**Your Ref:** OWPC15825  
**Our Ref:** M/94/17/PL 04-09-2017  
**Please ask for:**  
Mr D Easton

Demolition & erection of 1 No. dwelling with integral garage.  
72 Ancton Way Elmer Middleton on Sea

Thank you for your internet representation made on 12th October 2017 which has been recorded as '**an objection**' with the comments as follows:

Proposed Elevations
(1 of 2)

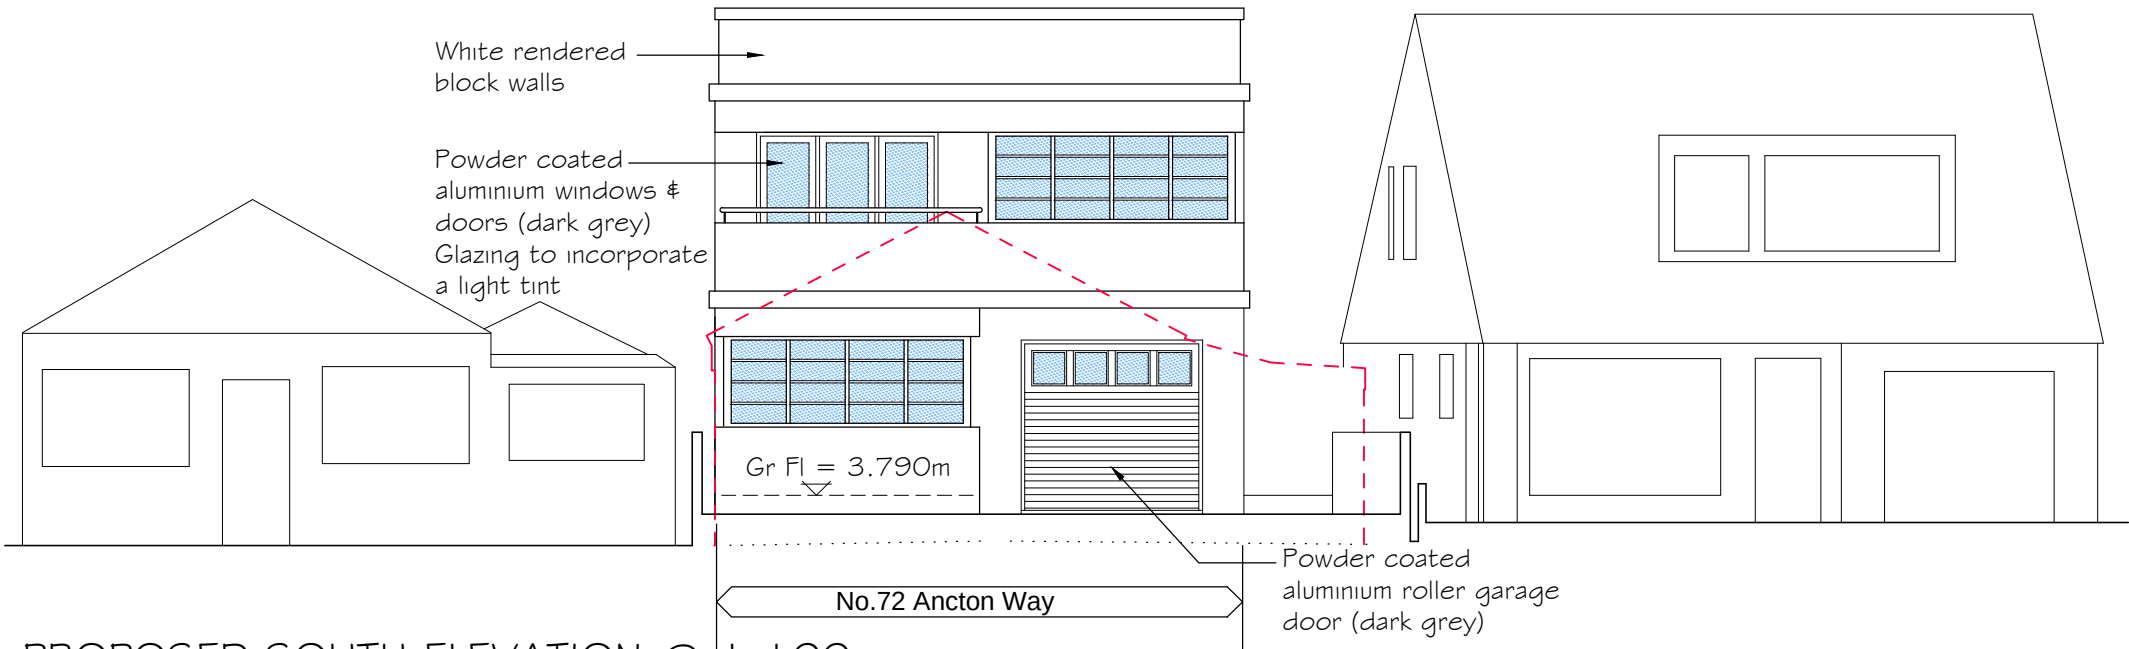
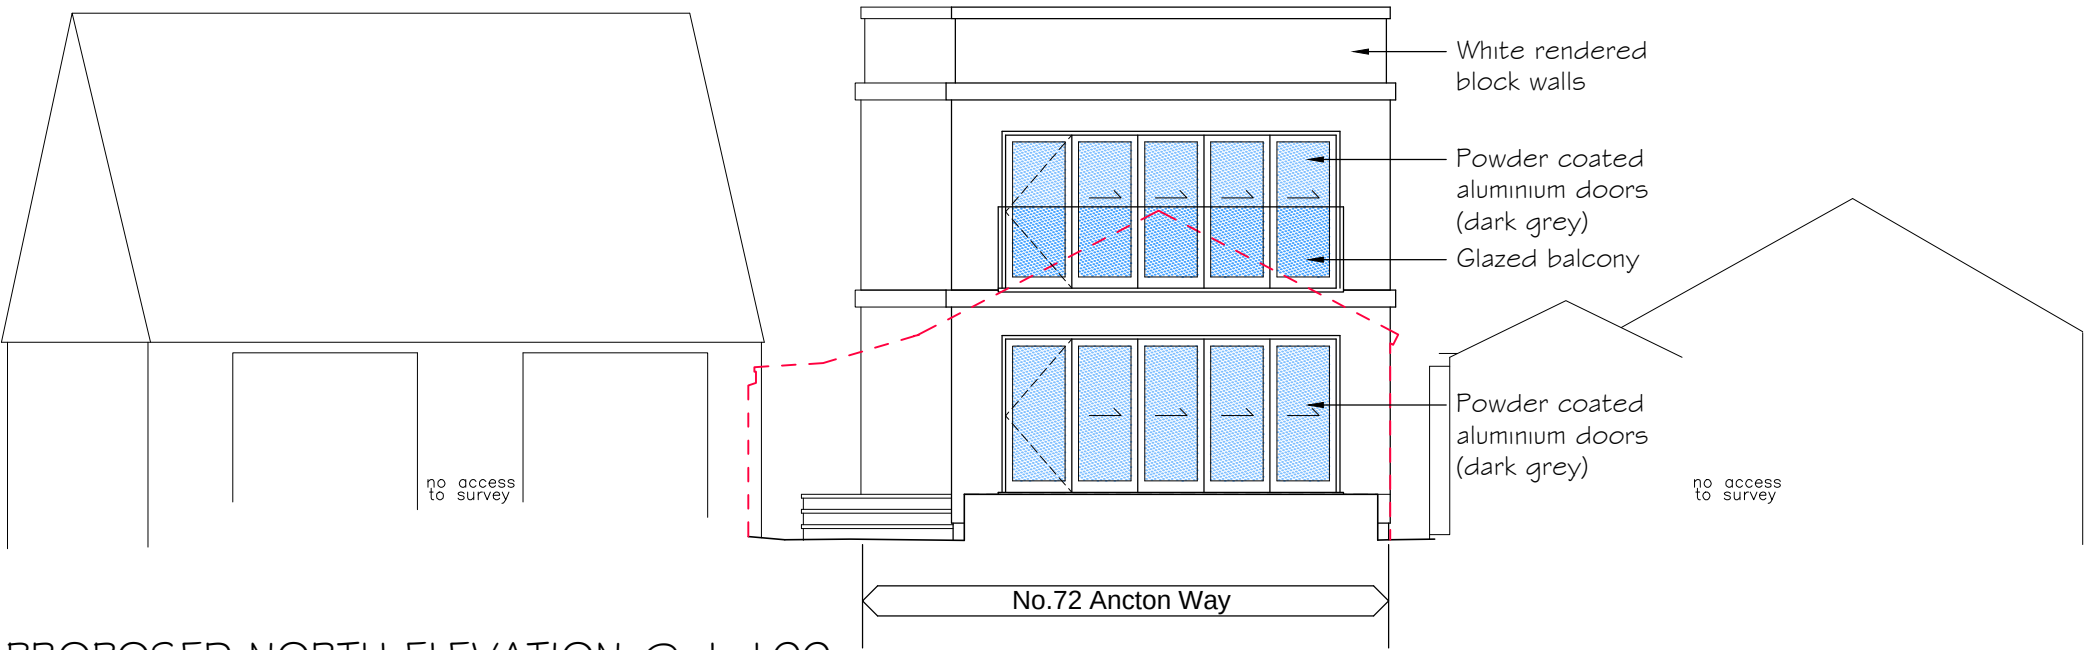
*After studying the proposed plans it is apparent that this style of build in not in keeping with the road it is in or the estate it is on and will be overpowering not only to the direct neighbours but the whole street. I see they have shown other similar buildings on the estate by the beech which although being block type builds they do have some shape and character.*
